## LETTER OF TRANSMITTAL

**Niederman Residence**

**Critical Area Determination CA017-001 First Review Letter – RESPONSE LETTER**

In response to your First Review Letter, dated May 3, 2017, kindly accept this letter and all referenced attachments as my formal response on behalf of our clients, Nicole & Chris Niederman. I trust that with this info in hand, you'll find that we're in compliance with the zoning code, Title 19 of Mercer Island City Code (MICC) for our proposed land use application. In direct response to your notes, please find my numerated response below.

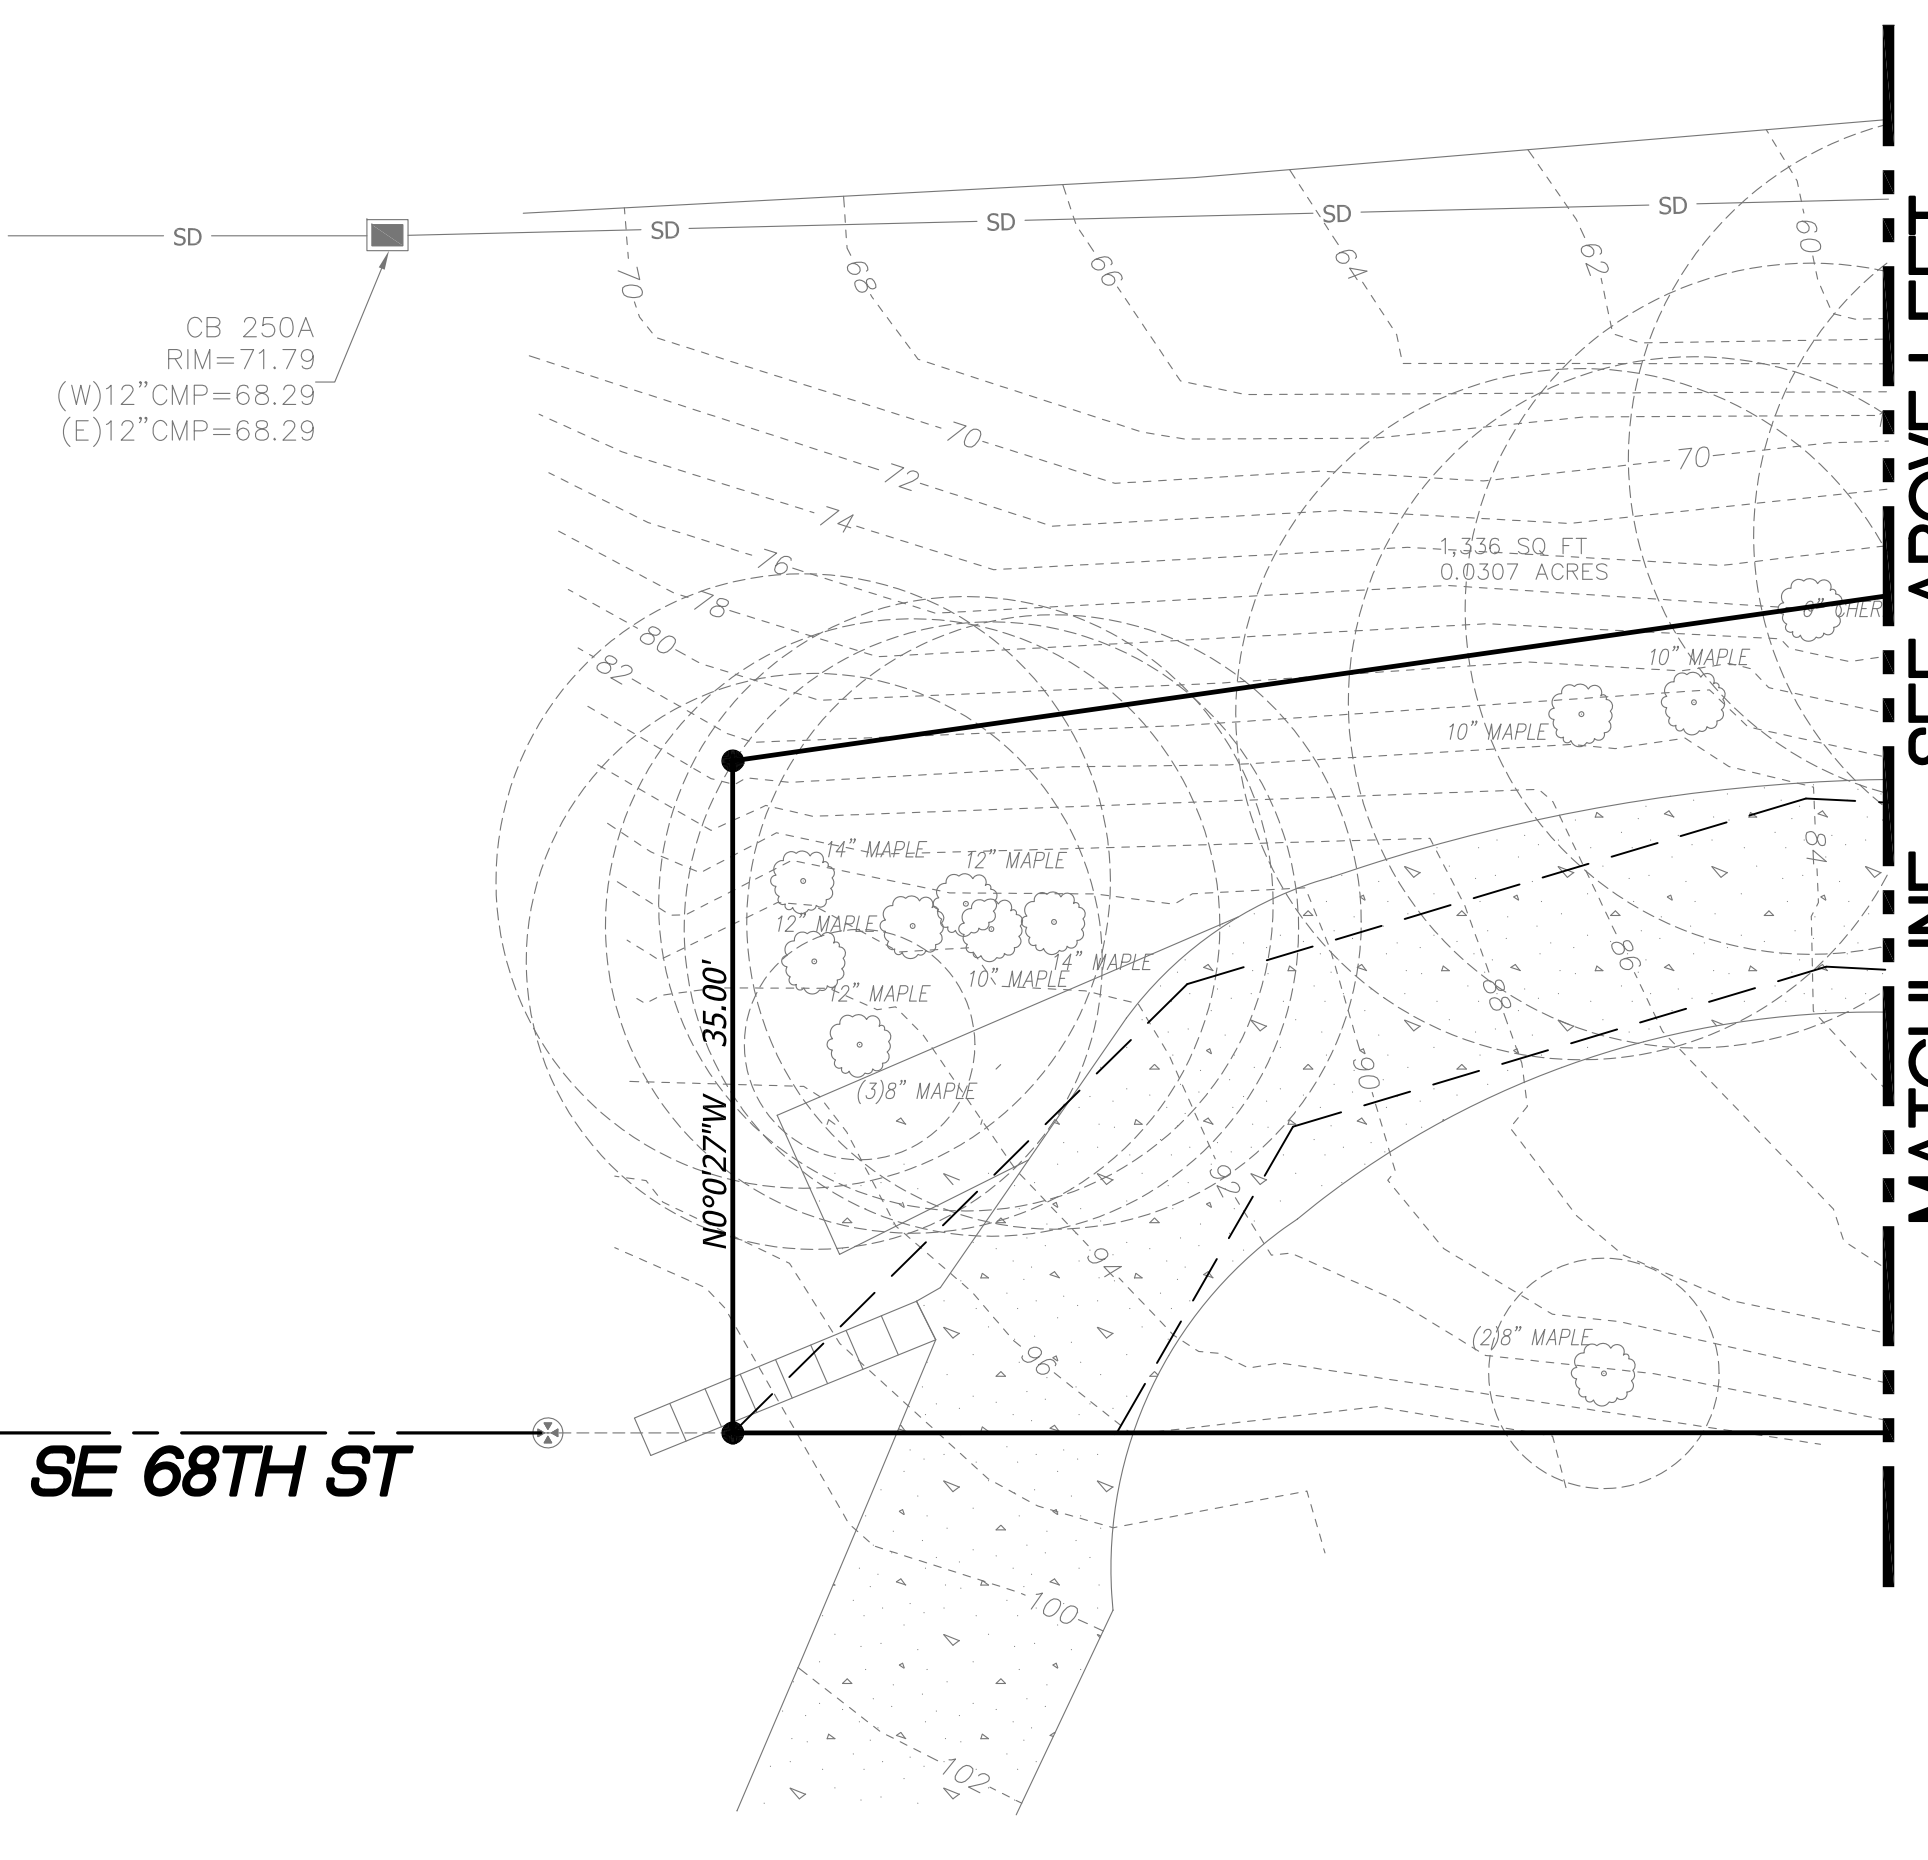
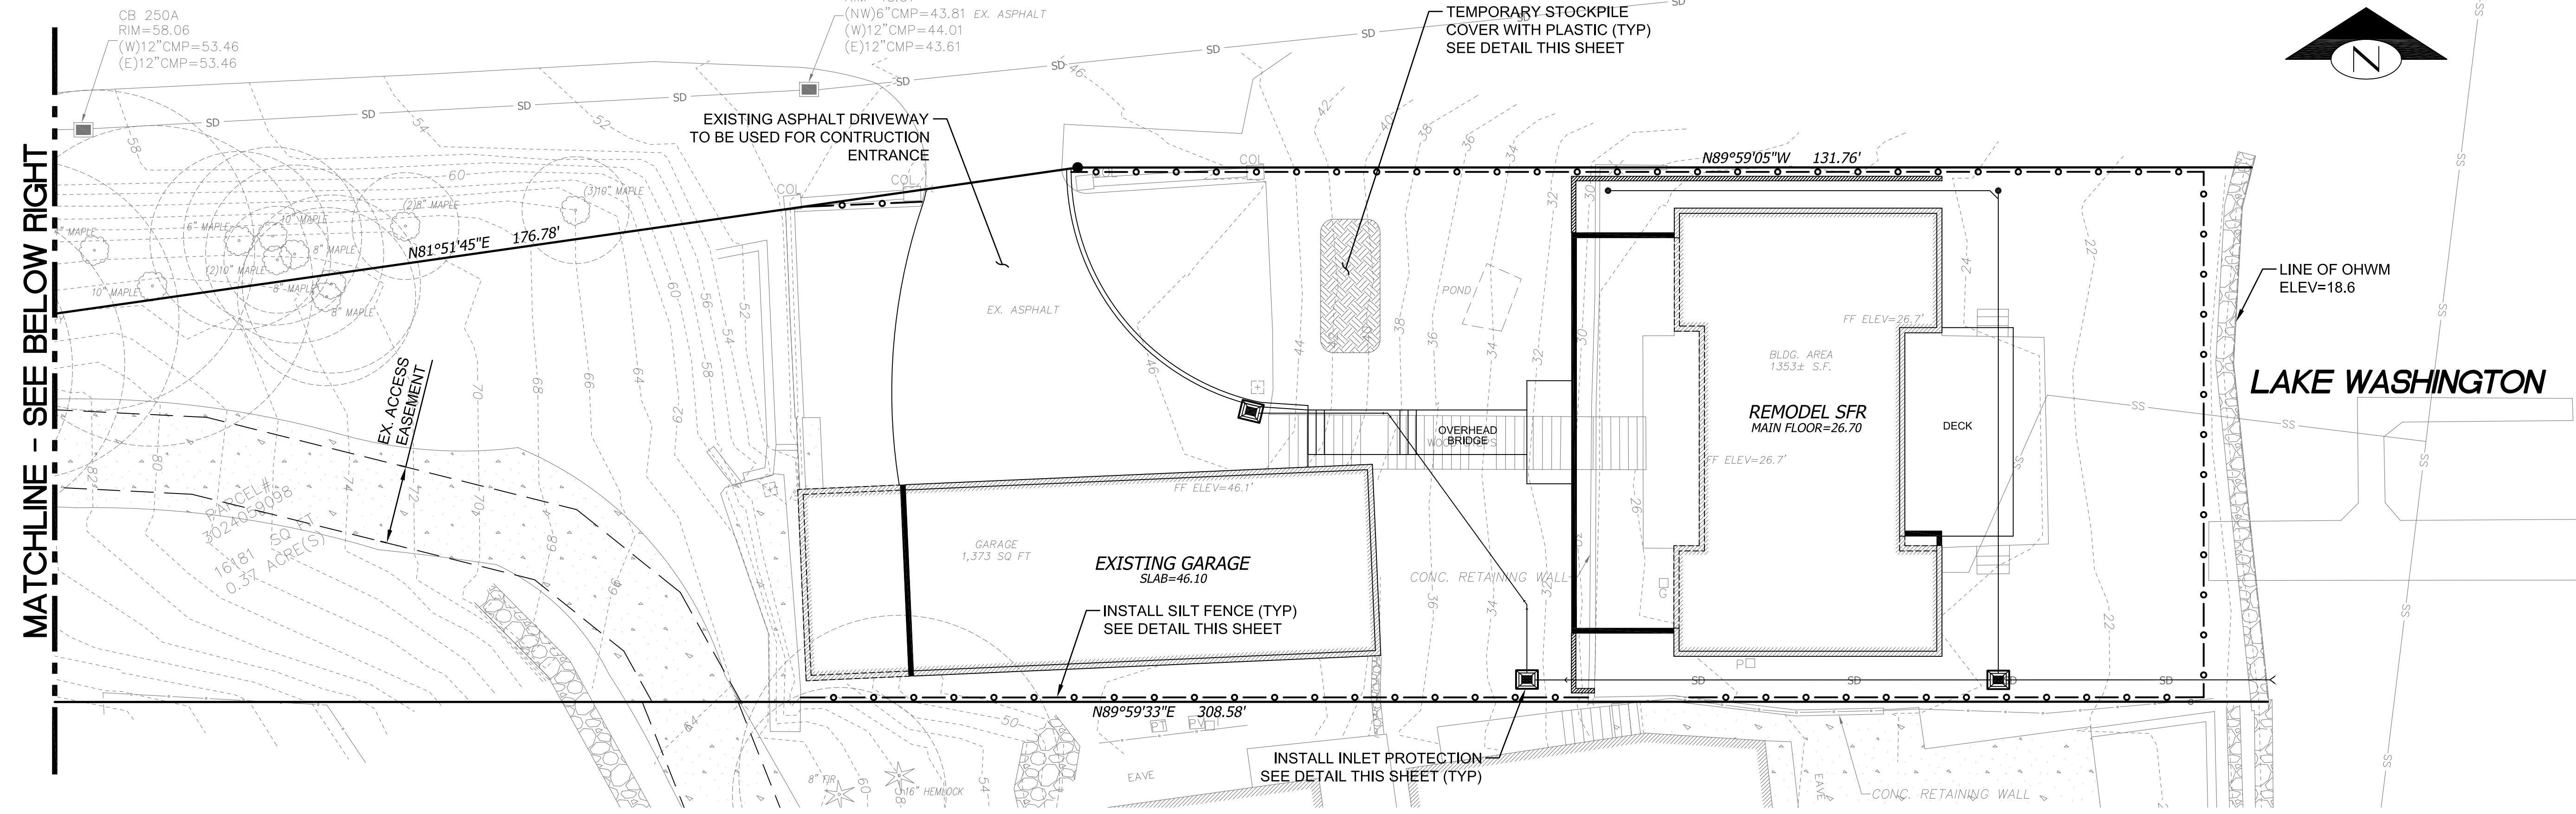
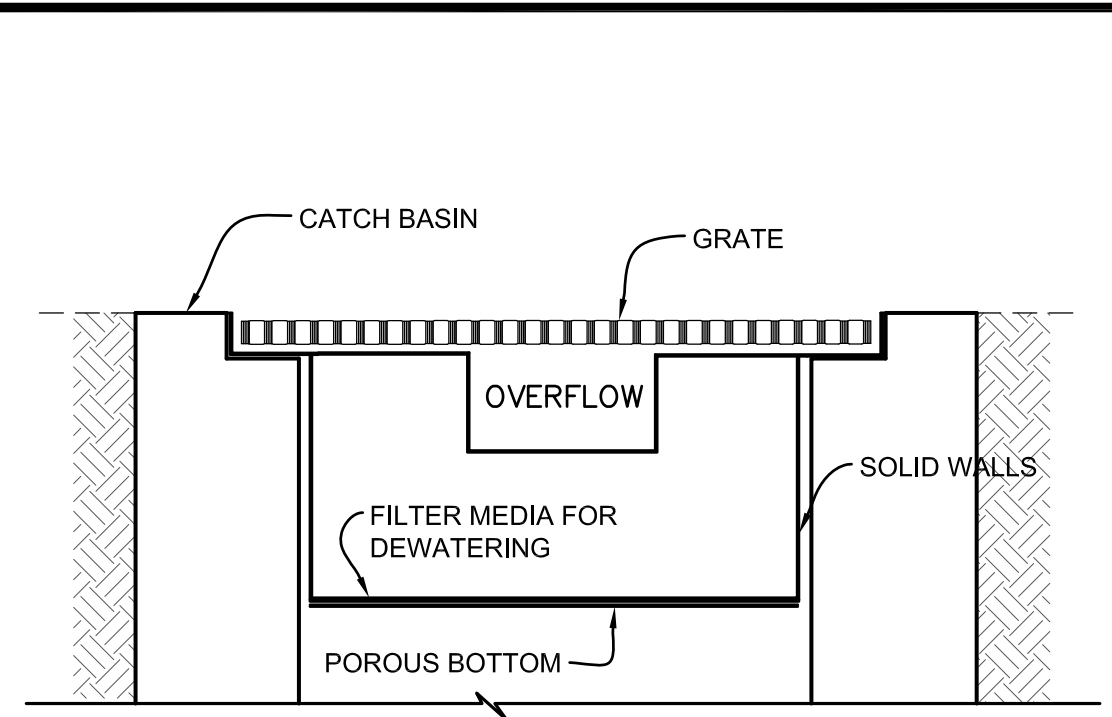
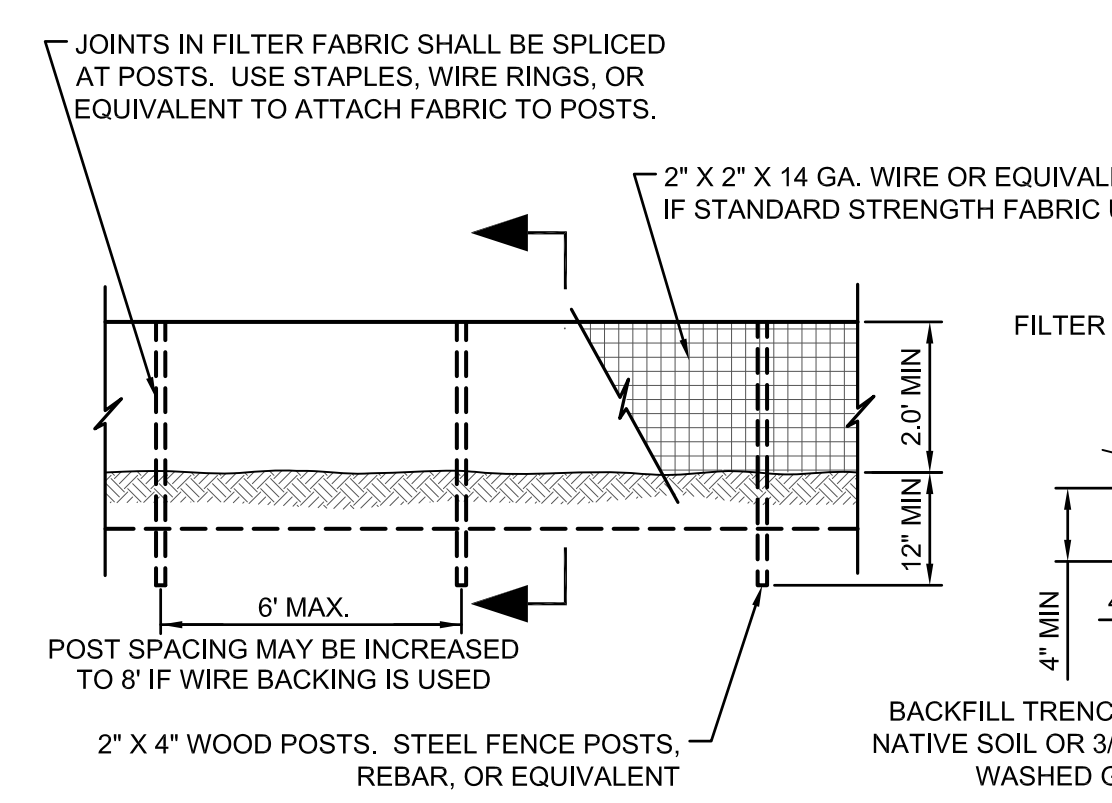
2. *Please provide a stormwater management plan associated with Site Development.*

- ii. The location which the concrete is being removed is not an RV parking space but rather the old driveway that was covered by the current access road. The runoff that is coming off the road currently is not diverted down the steep slope.

- iii. The existing piped watercourse is limited to capturing runoff from the private driveway not to mitigate additional or change in runoff.

- Attached, PBG's C1. TESC Plan & Details
- Attached, PBG's C2. Stormwater / Utility Plan & Details

- Per attached TESC & Stormwater Plans, runoff will be managed appropriately.

- Per attached TESC & Stormwater Plans, runoff will be managed appropriately & separately from the piped watercourse.
